From: Robert Peterson <Robert.Peterson@blacktown.nsw.gov.au>
Sent: Monday, 30 November 2015 12:28 PM
To: Georg Eberl
Subject: RE: MP 06_0239 Proposed Pre-Sort Enclosure, Genesis Waste Facility – Response to Submissions – stormwater
Attachments: RE: Genesis Xero Waste Facility - Eastern Creek Stormwater Management Plan

From: Jane.Flanagan@planning.nsw.gov.au [<mailto:Jane.Flanagan@planning.nsw.gov.au>]
Sent: Monday, 30 November 2015 11:24 AM
To: Judith Portelli
Cc: georg.erbel@blacktown.nsw.gov.au; David.Mooney@planning.nsw.gov.au
Subject: MP 06_0239 Proposed Pre-Sort Enclosure, Genesis Waste Facility – Response to Submissions – stormwater

The proponent has sent us emails from council indicating no objection to the *Proposed Future Stormwater Management Plan* (Dwg No. SKC007, Issue 6, dated 26/10/2015).

Civil Engineers and Project Managers	at&l	FOR INFORMATION NOT TO BE USED FOR CONSTRUCTION	A1
Suite 702, 154 Pacific Hwy St Leonards NSW 2065 ABN 96 130 882 405 Tel: 02 9439 1777 Fax: 02 9460 8413 www.atl.net.au info@atl.net.au	Drawing No.	Project No.	Issue
	SKC007	15-309	P6

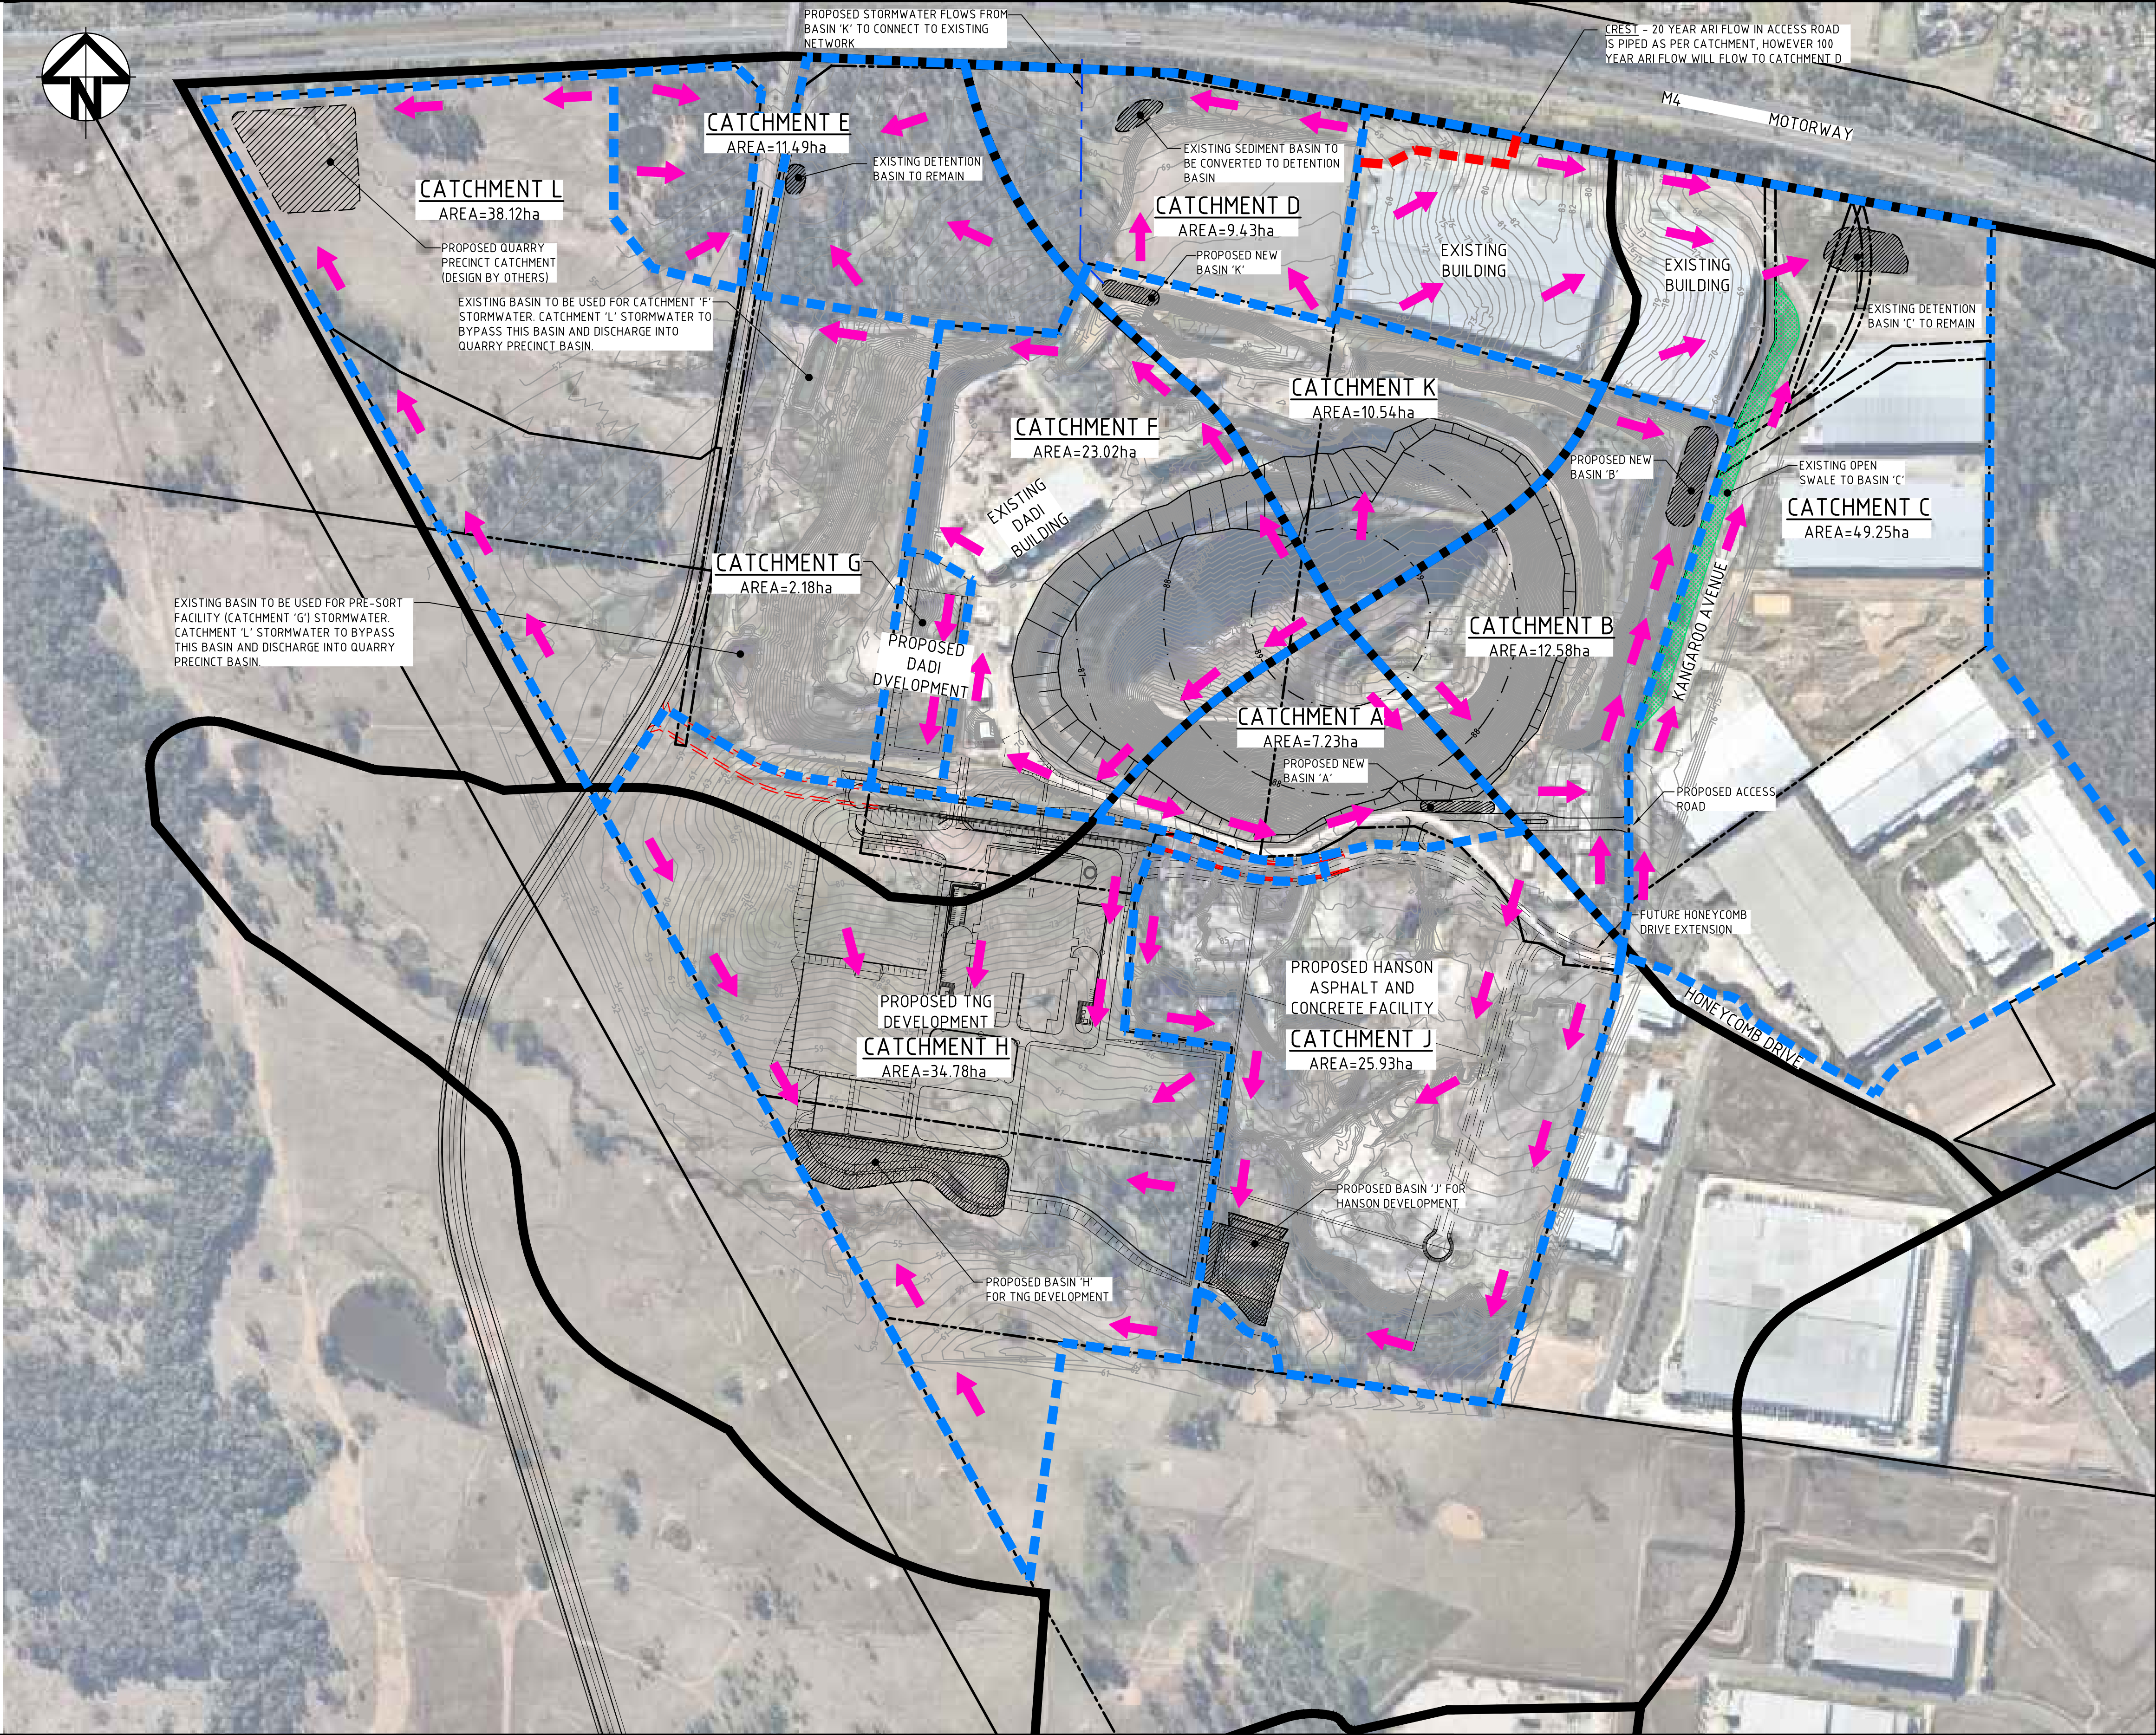
The plan is satisfactory for the proposed works, considering the applicant's response on our comments (see their comments and our response attached). As a result, there are no objections to using the current basins subject to them being augmented as required to meet the stormwater performance requirements

Please note that there are long term concerns that of how this area will be managed, as per our comments in the attached email, viz:

- *Ultimately the stormwater runoff (quality and quantity) from both catchments must be managed onsite (i.e. with the Lighthorse boundaries as defined in the LEC decision) Lot 1 DP 1145808.*
- *While expansion of the current temporary basins will satisfy the required stormwater management outcomes, this is generally not supported as it is not part of the long term solution*

This is due to the fact that the applicant wants to use the existing basins to manage the runoff from land within the Lighthorse boundaries, on land that is outside of those boundaries. Runoff from the area on which the existing basins will be ultimately be managed in the future neighbourhood basin downstream.
